Appeal Decision

Appeal Ref: APP/R4408/D/24/3347069

88 Intake Lane, Pogmoor, Barnsley S75 2HY

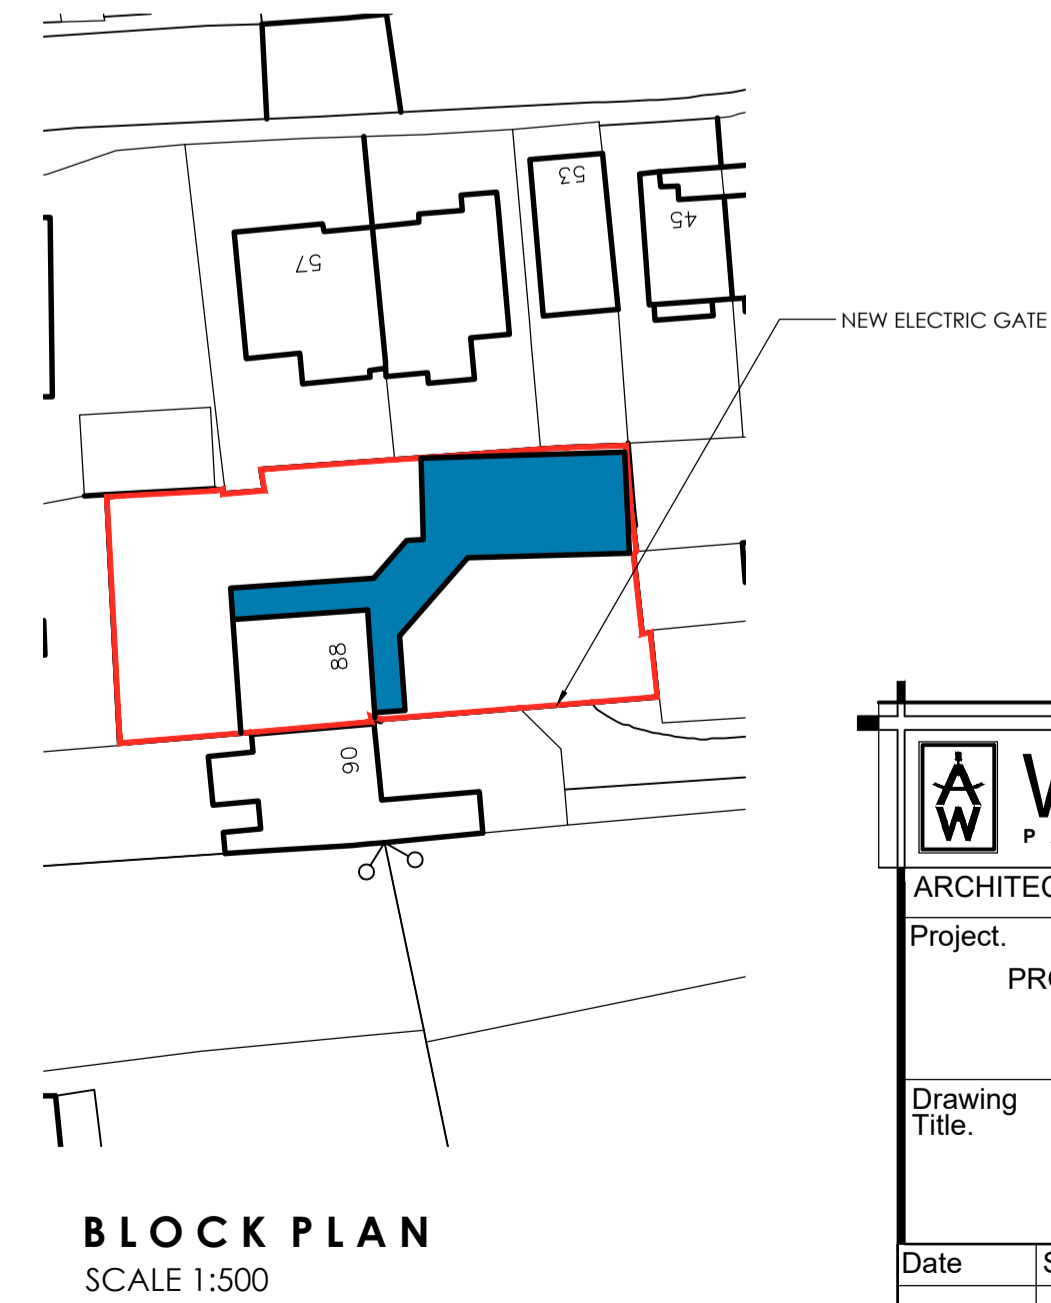
6. The proposal includes a two and a half storey side extension, flat roof dormer to the rear roof plane, single and one and a half storey extensions to the front elevation and a link structure between the house and the detached garage, which would be converted to an annex. The refused planning application subject to this appeal was a resubmission of a previously approved application¹ for an ostensibly similar proposal, with the change evidently limited to the addition of the link structure between the dwelling and garages. Although the appellant argues that the only aspect under consideration is the link structure, the whole proposal was refused, albeit I understand that the Council does not take issue with other elements approved under the previous grant of permission.

8. At present, the dwelling and garages are distinctly separate with a host and ancillary relationship. The link extension would project a significant distance from the front elevation of the host dwelling. Although the rear of the structure would be 2.4m due to the angle of projection, the longer, front section would evidently extend some 6.8m, adding significant built form in order to close the gap and join the two structures. The resulting extension overall would be a long, asymmetrical projection which would overwhelm the front elevation of the existing property. The pleasing simple form and proportions would be harmfully impacted as a result, which would be further compounded by the repositioning of the front door to the link, highlighting the incongruity despite facing a similar direction. Taken together, the proposal would detract from the quality of the existing dwelling, contrary to the guidance in the SPD.

13. Overall, the proposal would detract from the quality of the existing dwelling, harming its character through its overly dominant scale and design. Regardless of whether 'links' are explicitly referenced in the wording, the proposal would be contrary to policy D1 of the Barnsley Local Plan (adopted January 2019). This states that through its design, development should display architectural quality and express proposed uses through its composition, scale, form, and proportions, among other things. The proposal would also be contrary to the design advice in the SPD as demonstrated above which weighs further against the scheme.
